CITY OF ALBUQUERQUE

June 20, 2019

Re: Champion Xpress Car wash
4516 Wyoming Blvd NE, 87111
Traffic Circulation Layout
Engineer's/Architect's Stamp 5-10-19 (F20D005)

Design: RJM	Proj: 18.160
Draw: RJM	Dwg: 18-160.dwg
Check: JDB	Tab: C5.0-DET
Scale: N/A	
Date: 01.04.2019	
Sheet:	
SITE DETAILS	
Sheet No.:

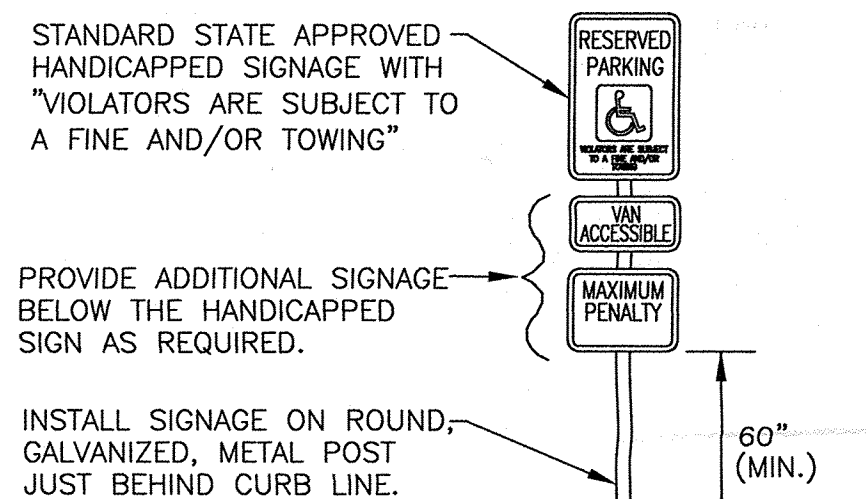
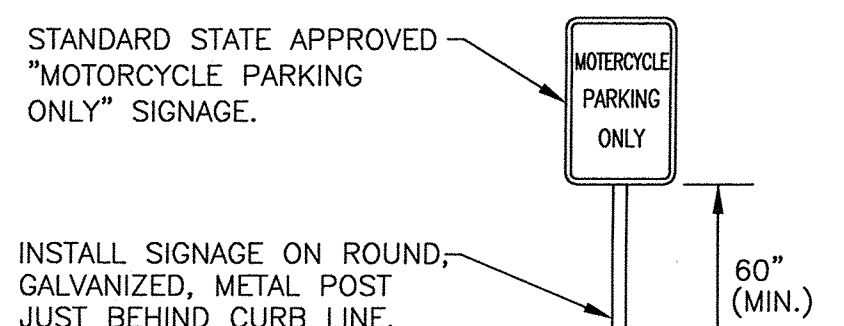
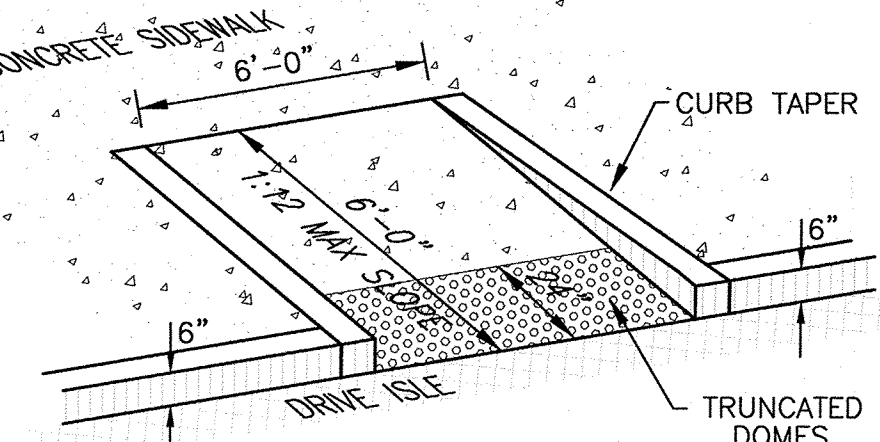
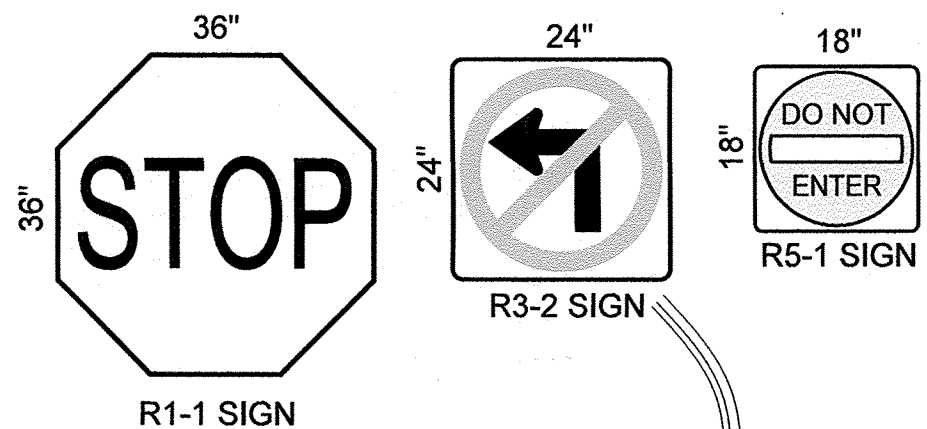
2. Motorcycle parking spaces should be its own individual spaces. (Please remove hatch pavement marking)
3. The ADA access aisles shall have the words **"NO PARKING"** in capital letters, each of which shall be at least one foot high and at least two inches wide, placed at the rear of the parking space so as to be close to where an adjacent vehicle's rear tire would be placed. (66-1-4.1.B NMSA 1978)

4. The ADA accessible parking sign must have the required language per 66-7-352.4C NMSA 1978 **"Violators Are Subject to a Fine and/or Towing."**
5. Per the IDO, a 6 ft. wide ADA accessible pedestrian pathway is required from the public sidewalk to the building entrances. Please clearly show this pathway and provide details. (Please design to also connect to building to south)

Design: RJM	Proj: 18.160
Draw: RJM	Dwg: 18-160.dwg
Check: JDB	Tab: C2.0-TCLP
Scale: 1" = 20'	
Date: 01.04.2019	
Sheet: C-2.0

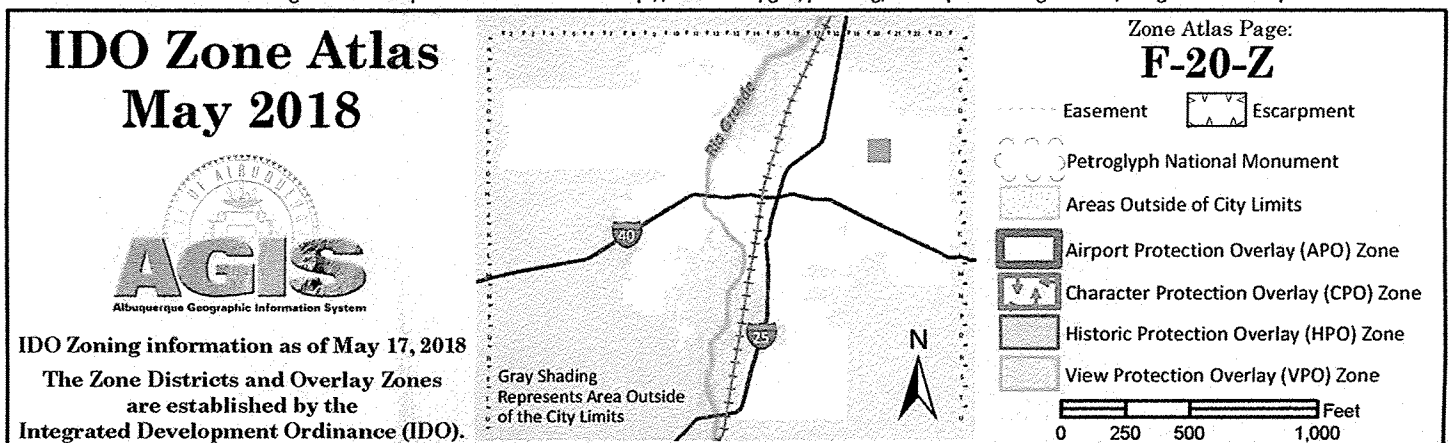
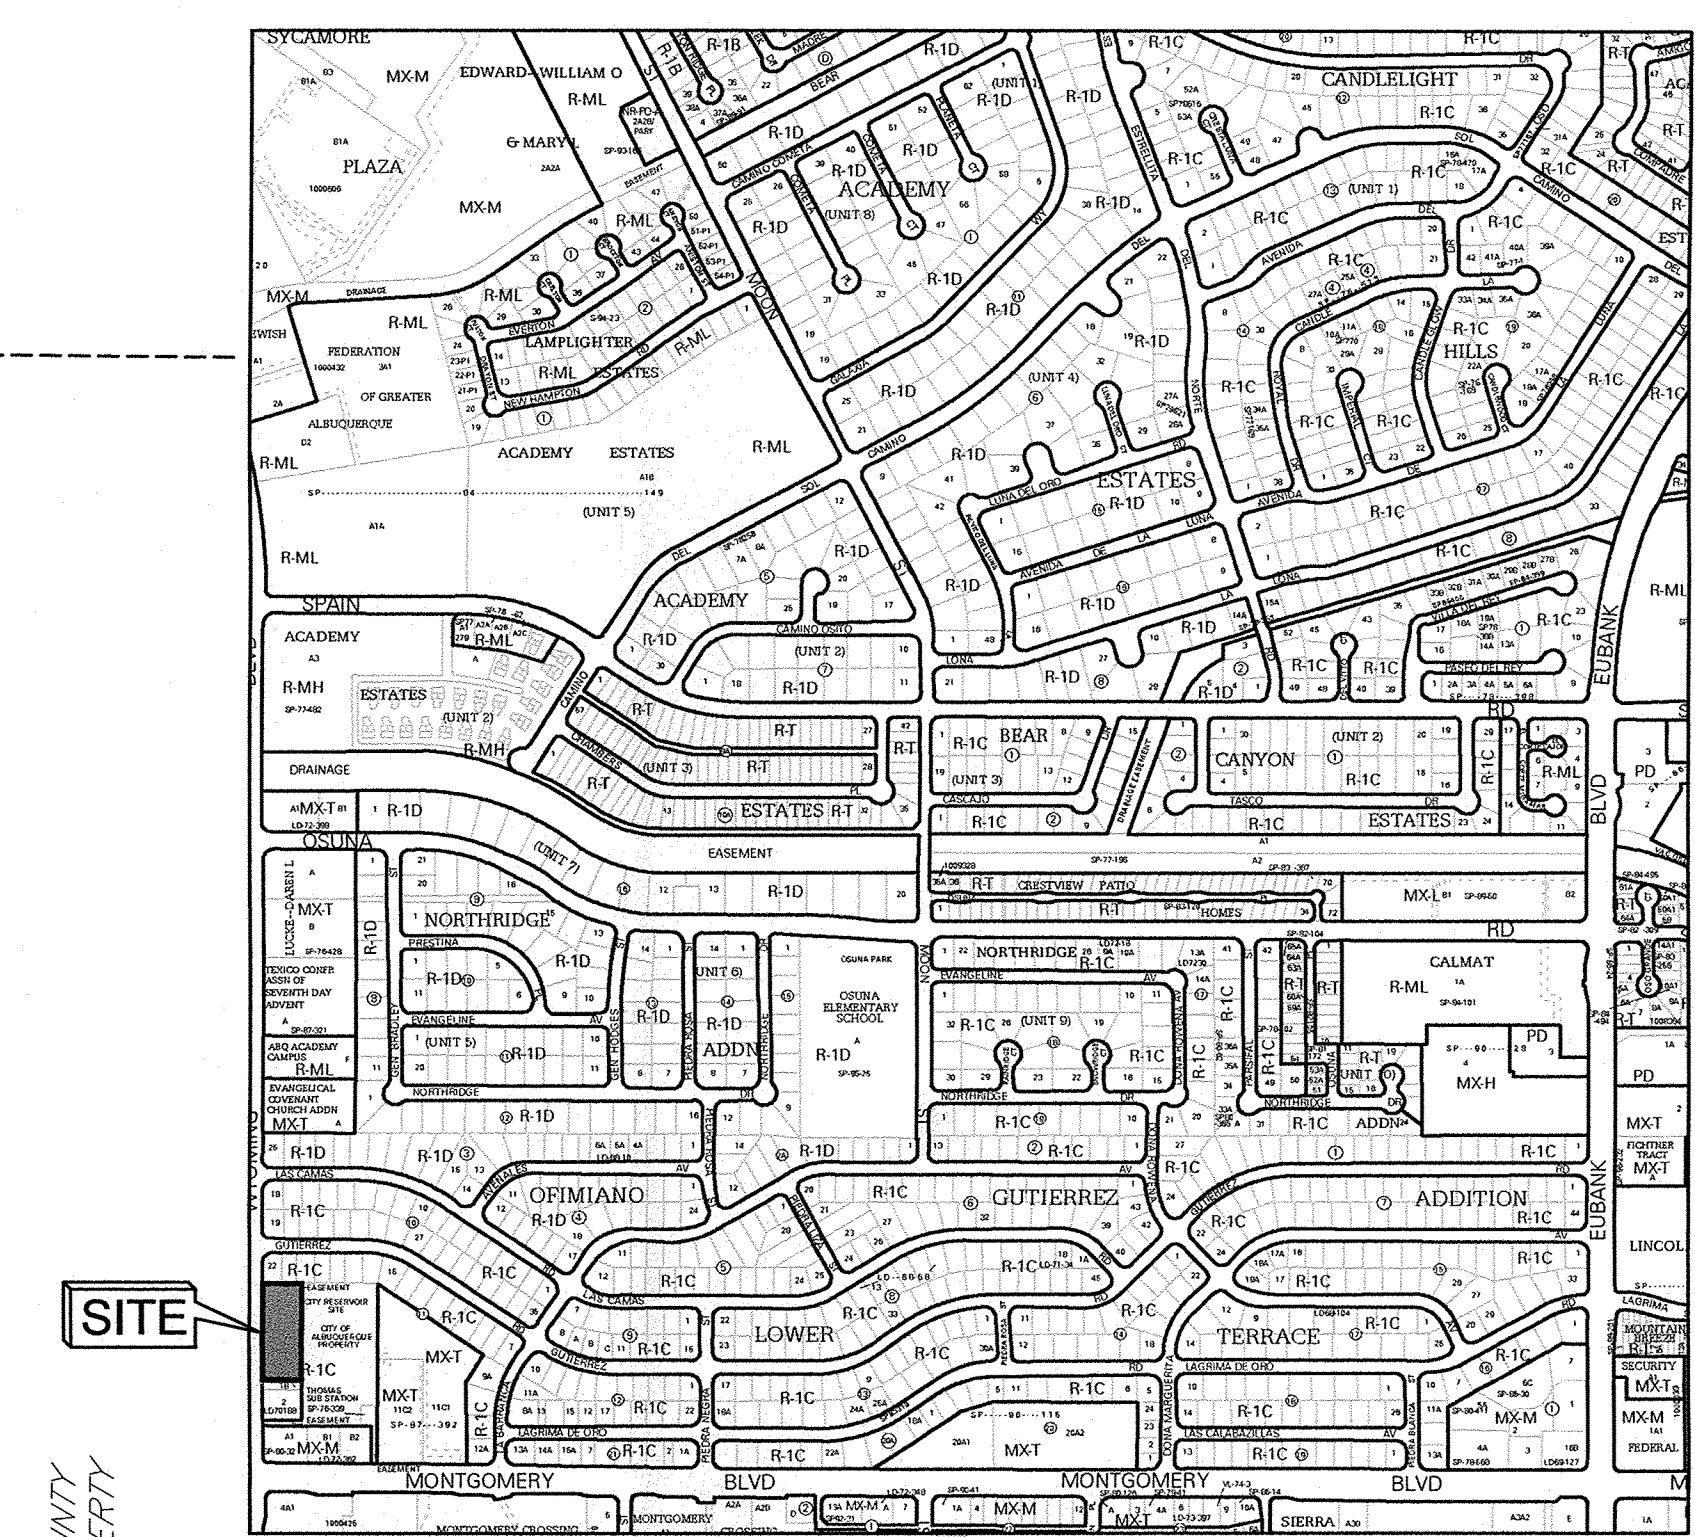
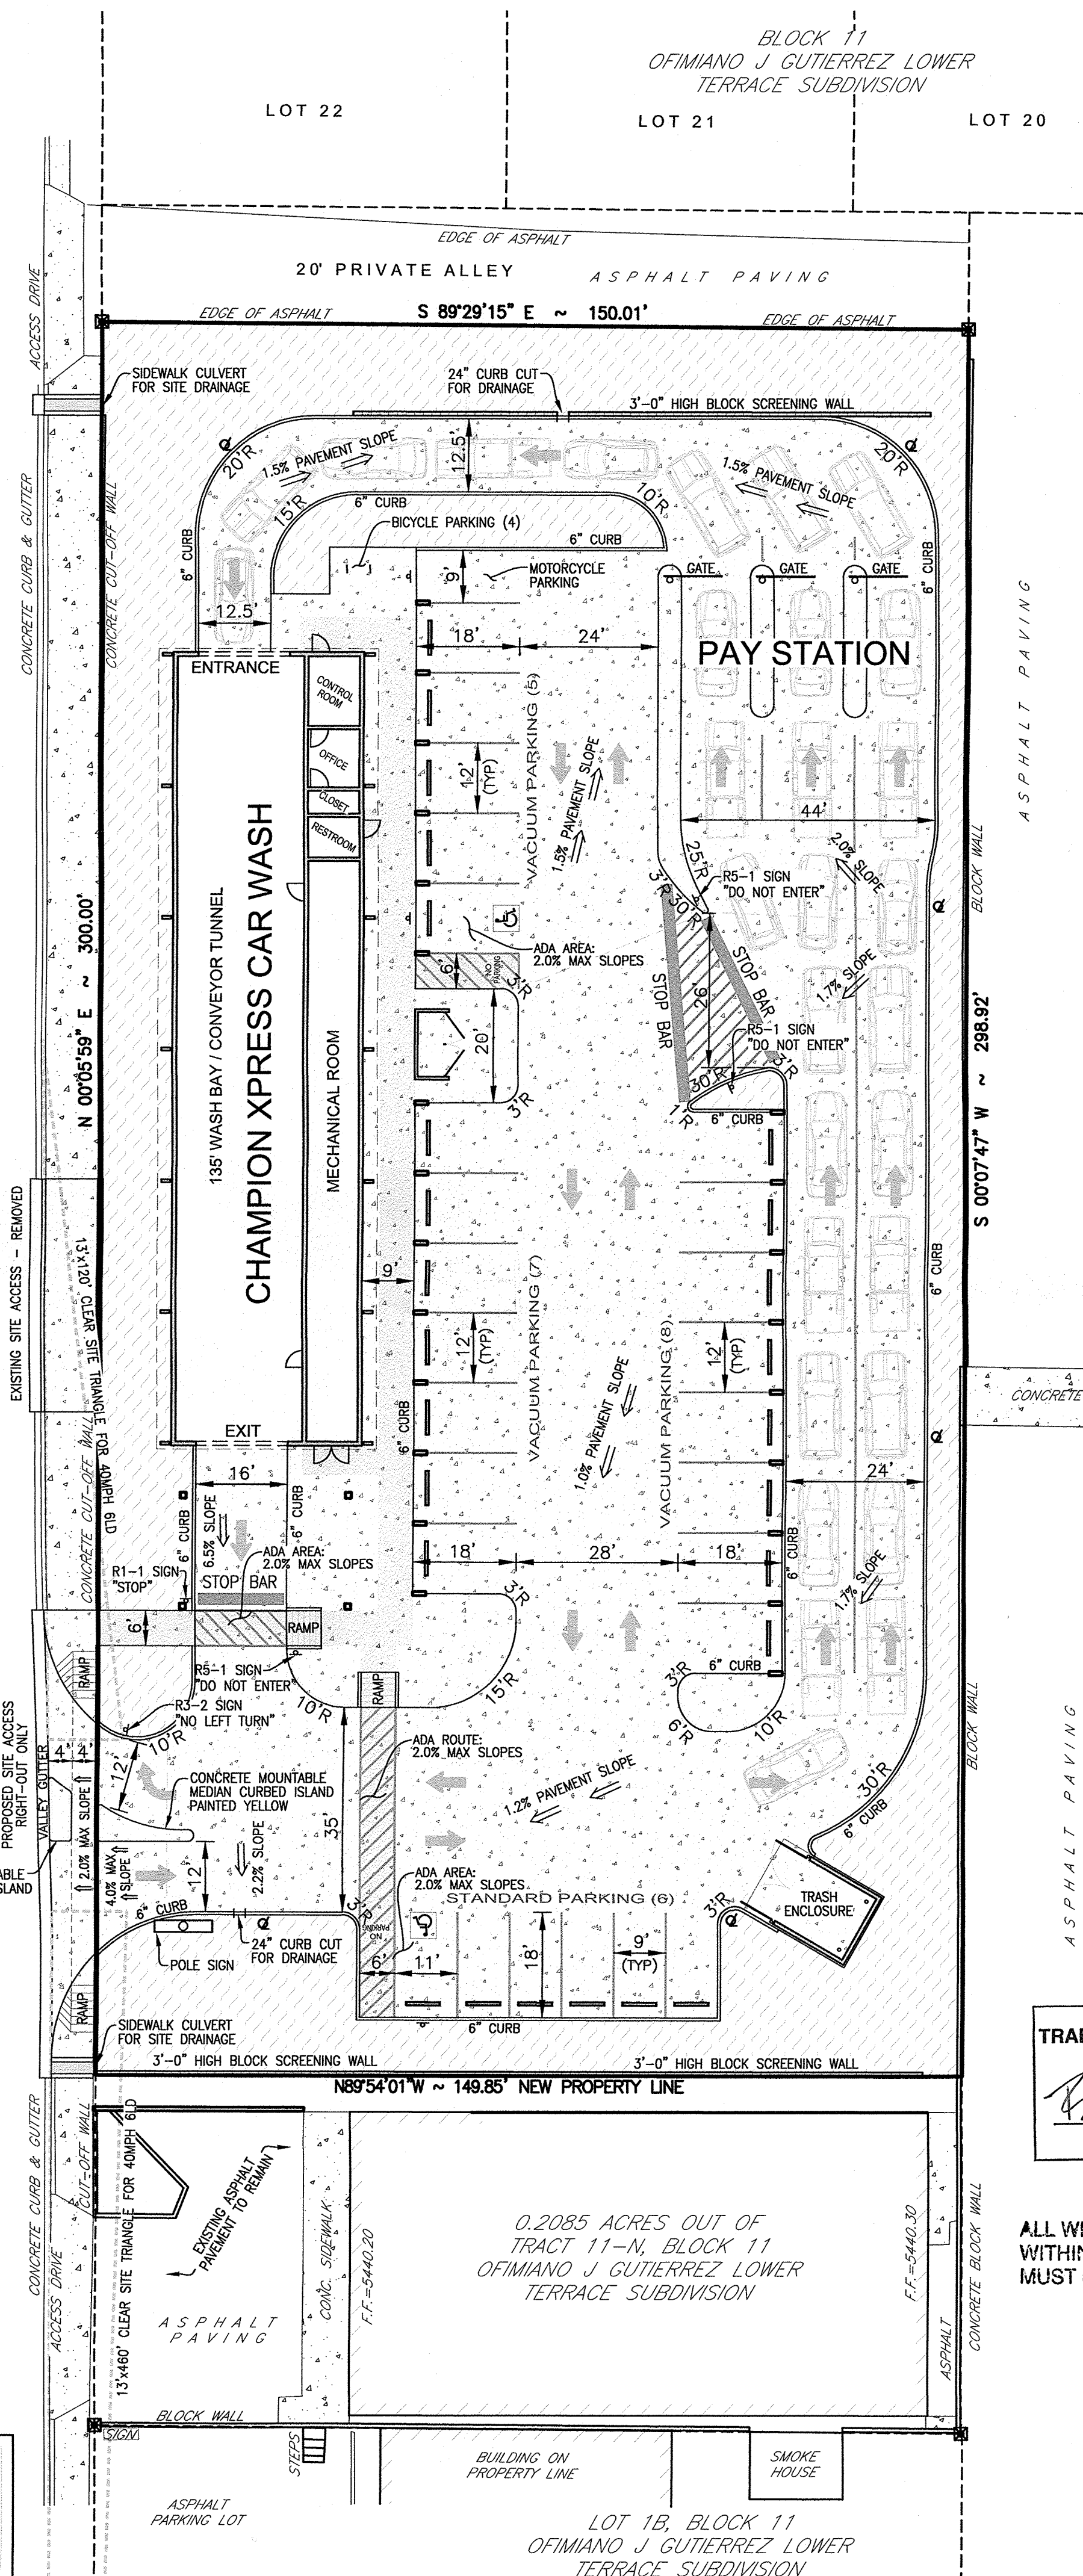
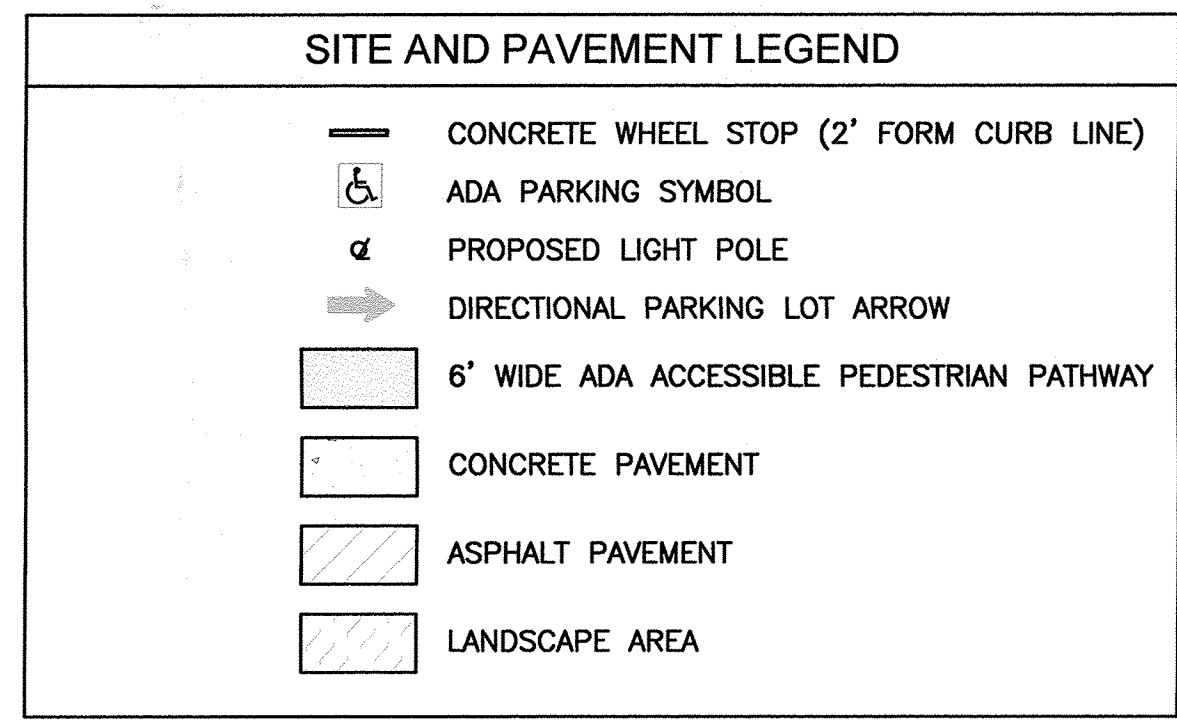
1. List the number of parking spaces required by the IDO as well as the proposed number of parking spaces **including bicycle and motorcycle parking**.

6. Per DPM, a 6 ft. wide ADA accessible pedestrian pathway is required from the HC parking stall access aisles to the building entrances. Please clearly show this pathway and provide details.

7. Show the clear sight triangle and add the following note to the plan:
"Landscaping and signage will not interfere with clear sight requirements. Therefore, signs, walls, trees, and shrubbery between 3 and 8 feet tall (as measured from the gutter pan) will not be acceptable in the clear sight triangle."

8. Please include a copy of your shared Parking agreement with the adjacent property owner.
9. Please move No Left Turn Sign closer to sidewalk.

10. Please use pork chop style concrete mountable median curb island to force right turn only.
11. Minimum lane widths are 12 feet minimum. (Drive thru pay station aisles)
12. Please add a note on the plan stating "All improvements located in the Right of Way must be included on the work order."
13. Please provide a copy of refuse approval.
14. One-way vehicular paths require pavement directional signage and a posted "**Do Not Enter**" sign at the point of egress. Please show detail and location of posted signs. (Exit of wash bay & Entrance leading to pay stations)
15. Please use decimal points when indicating slopes. (2%, 4% & 6% should indicate 2.0 %, 4.0 %, & 6.0%, some were missing)
16. Please include one copy of the traffic circulation layout at the next submittal.
